Consultation Response from KC, Highways Development Management		
2021/90357 East Bierley Playing Fields, Hunsworth Lane, East Bierley, BD4 6PU		
Works to existing sports facilities including erection of a clubhouse, additional changing facilities building, boundary treatments, storage facilities and floodlighting, works to existing pitches, and creation of new hybrid and five-a-side pitches and car park		
Date Responded:09-06-2021	Responding Officer: Mark Berry	Responding Ref: 8-7-11

Client	Title			
East Bierley Community Sports Association	Location Plan			
Project	Job No.	Dwg No.		
Estates Strategic Plan	EBSCA_02	01A		
	Scale	Date	Drawn	Checked
©Copyright EBSCA	A3@1:1250	Feb 21	AW	SA

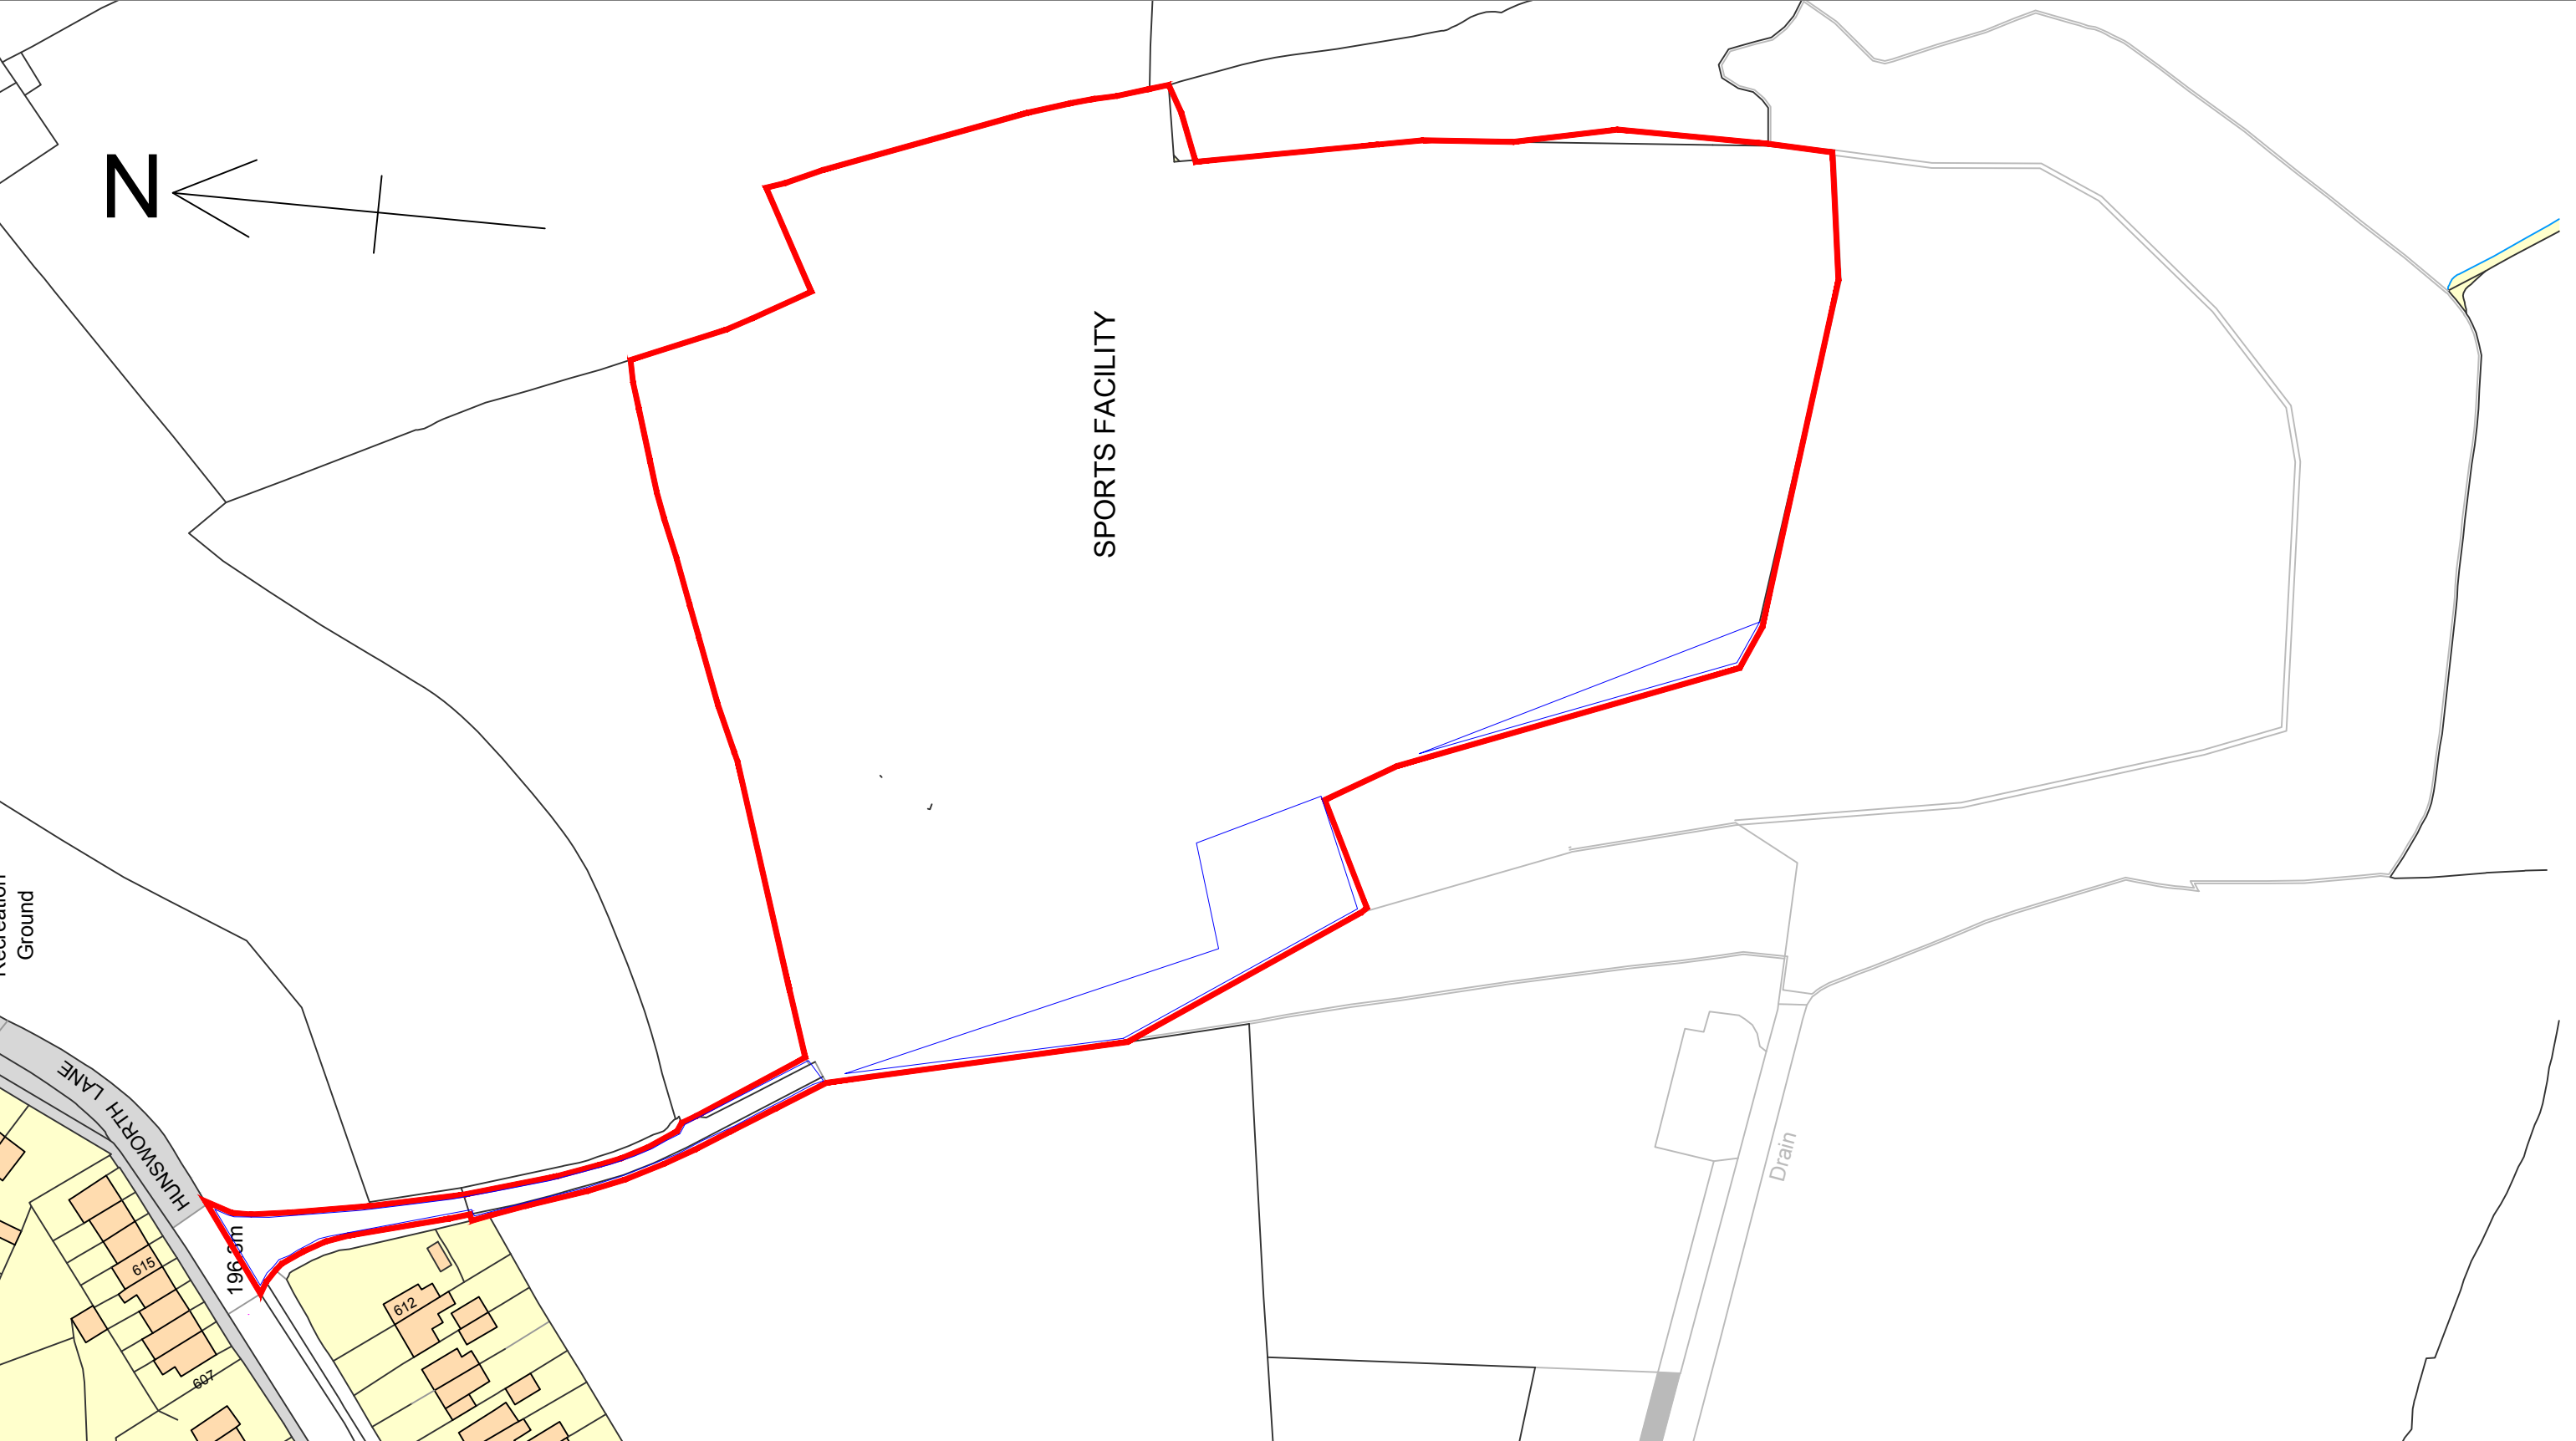
The proposals do not include any works to the 30-metre section of the existing track between the end of the Rouse improvement works and the proposed re-development which is not considered acceptable to HDM. This area is within the red line boundary and improvements works should be shown to be undertaken.

Client	Title			
East Bierley Community Sports Association	Existing & Proposed Site Plan			
Project	Job No.		Dwg No.	
	EBSCA_02		04D	
	Scale	Date	Drawn	Checked
A3@1:1250 Nov 20 AW SA				
Copyright EBSCA

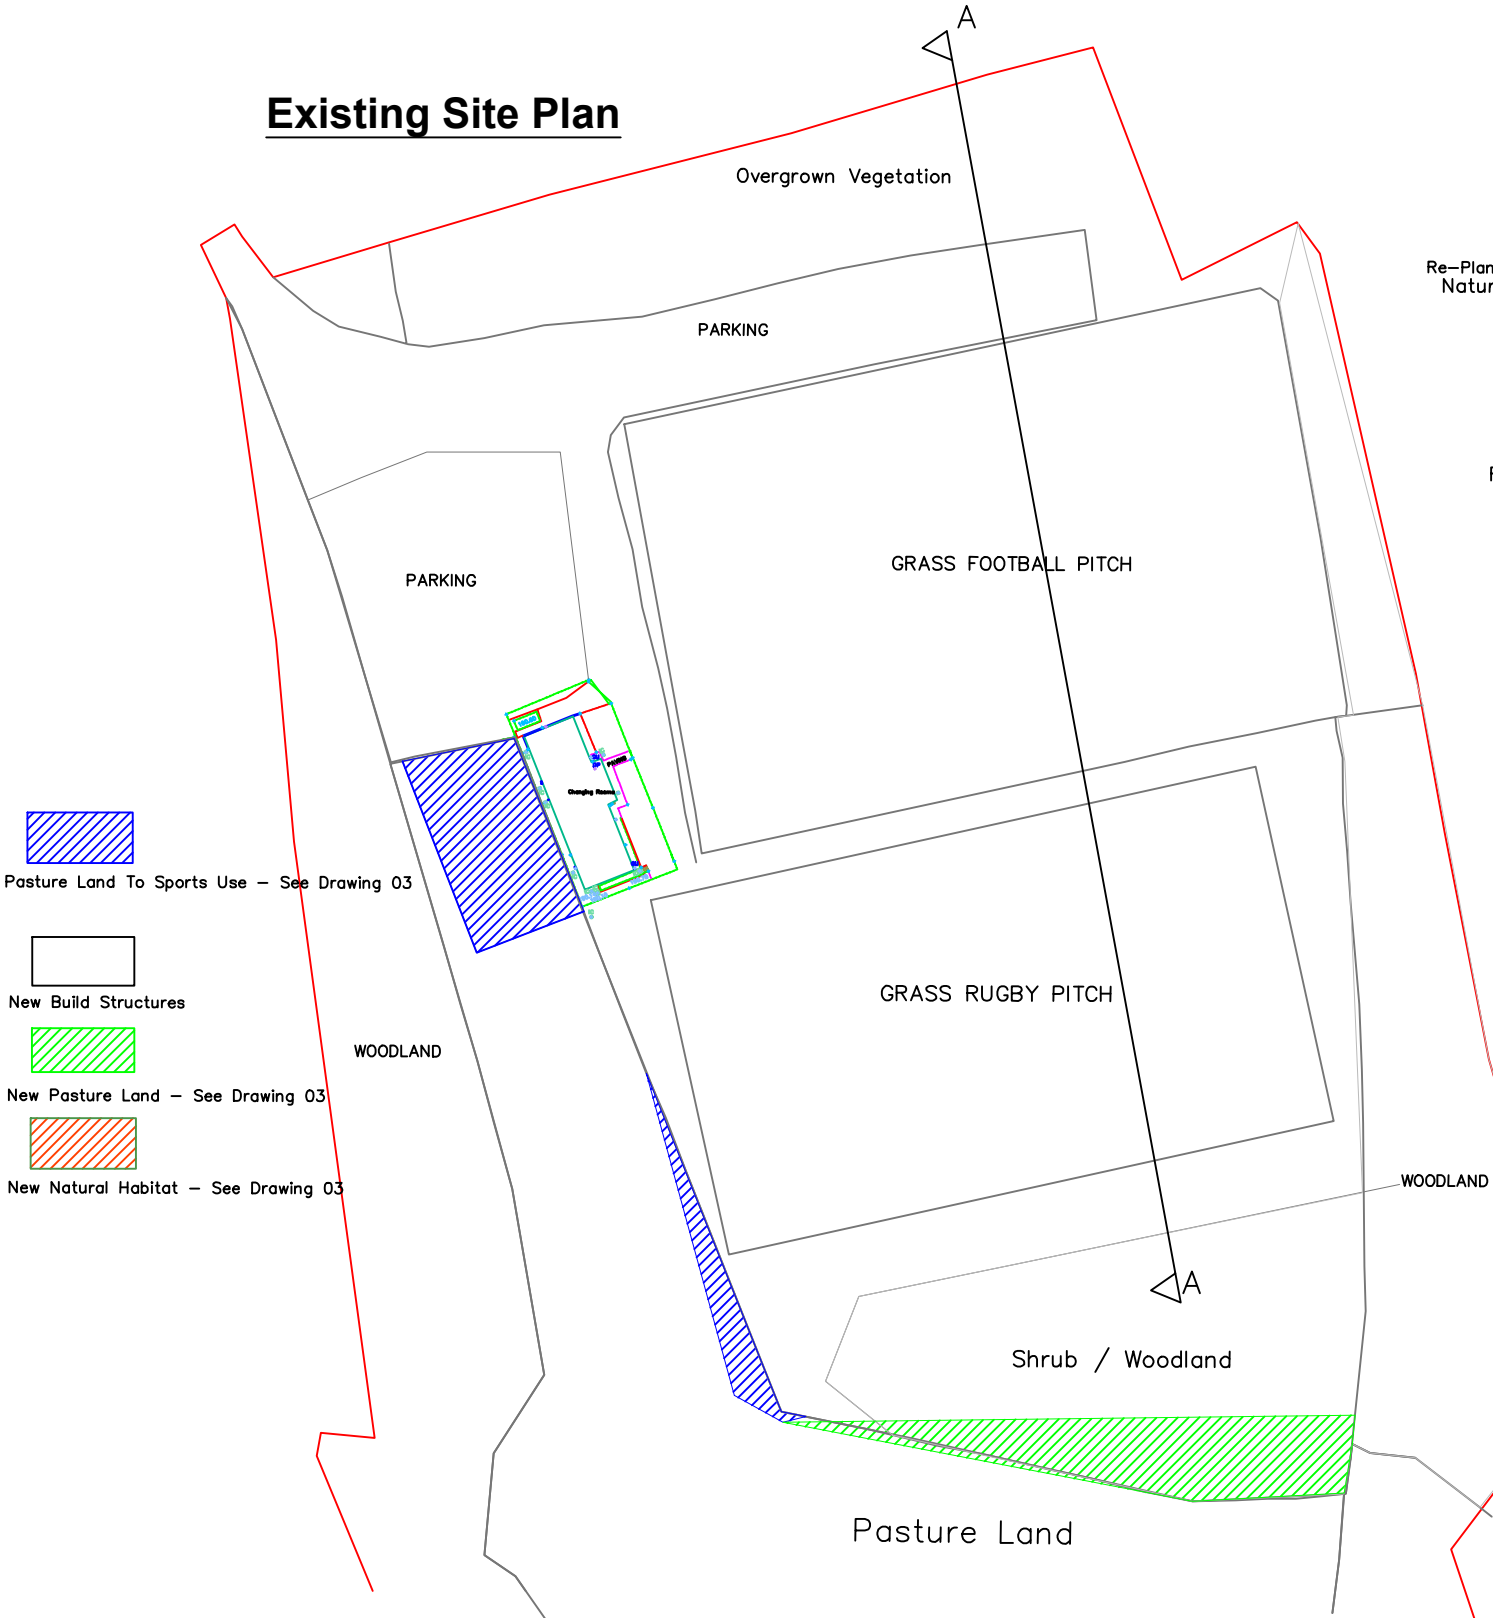
The proposals include the formalisation of the existing parking provision and overspill areas to provide a total of 150 car parking spaces including space for minibuses if required and cycle parking. No improvement works are proposed to the access track as part of this application.
